February 6, 2004

RE: Application for Minor Site Plan, Hope Avenue- Lot 29
(CBL#390B029) (ID#2003-0260)

January 28, 2004

RE: Application for Minor Site Plan, Hope Avenue- Lot 29
(CBL#390B029) (ID#2003-0260)

Plot Plan
Scale: 1" = 30'

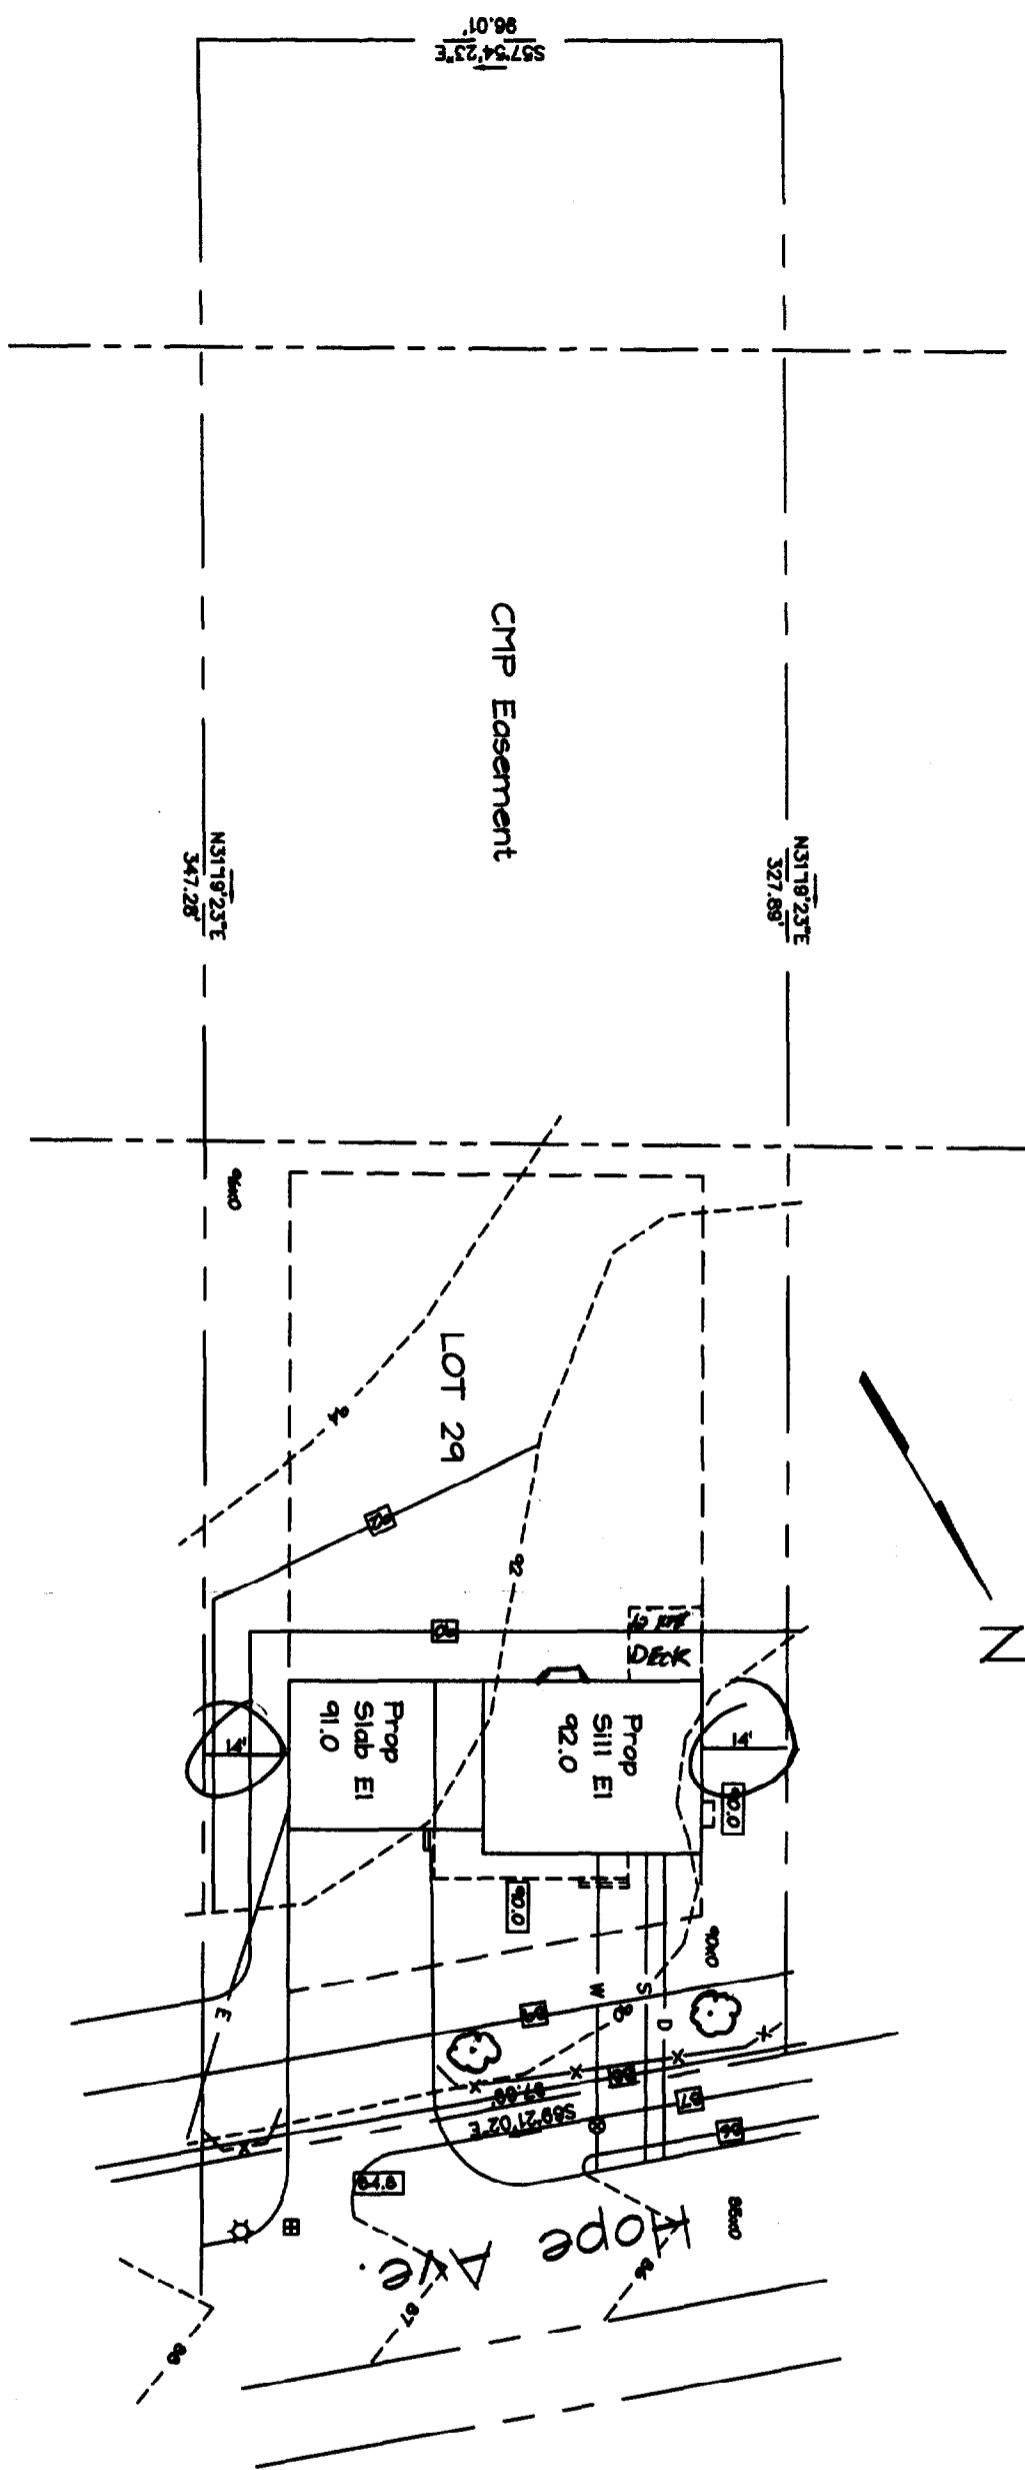
Upon review, it appears that your finish floor and garage floor elevations are still not coinciding with the current build-out of your foundation. Also, the proposed topography does not appear to be accurate and does not address the City's drainage concerns.

It appears that your finish floor elevation has been set approximately 5 feet higher than the proposed elevation on your site plan.

This change requires review and approval from the City.
Please submit to the planning office a revised site plan showing all variations/discrepancies from the approved site plan. This should include new proposed finish floor elevation, topography, drainage patterns, and any other features that this change may affect.

1. Planning Comments:
 - a. Please show proposed topography. This should tie into street grades, and most importantly, integrate well with proposed grades on the adjacent lot(s). I have included the approved site plan for lot 28 to help with this request.
 - b. The spot grades and elevations (sill and finish floor) do not match up to the actual grades as shown on the approved subdivision. All grades should be actual.
 - c. Please add two street trees along your street frontage (as required by ordinance for single family development).
 - d. Please add erosion control to site plan along the front of the lot.
 - e. The approved subdivision plan shows a light pole and catch basin near the entrance of the proposed driveway. Please show these on your site plan to ensure that your driveway location works with these utilities.
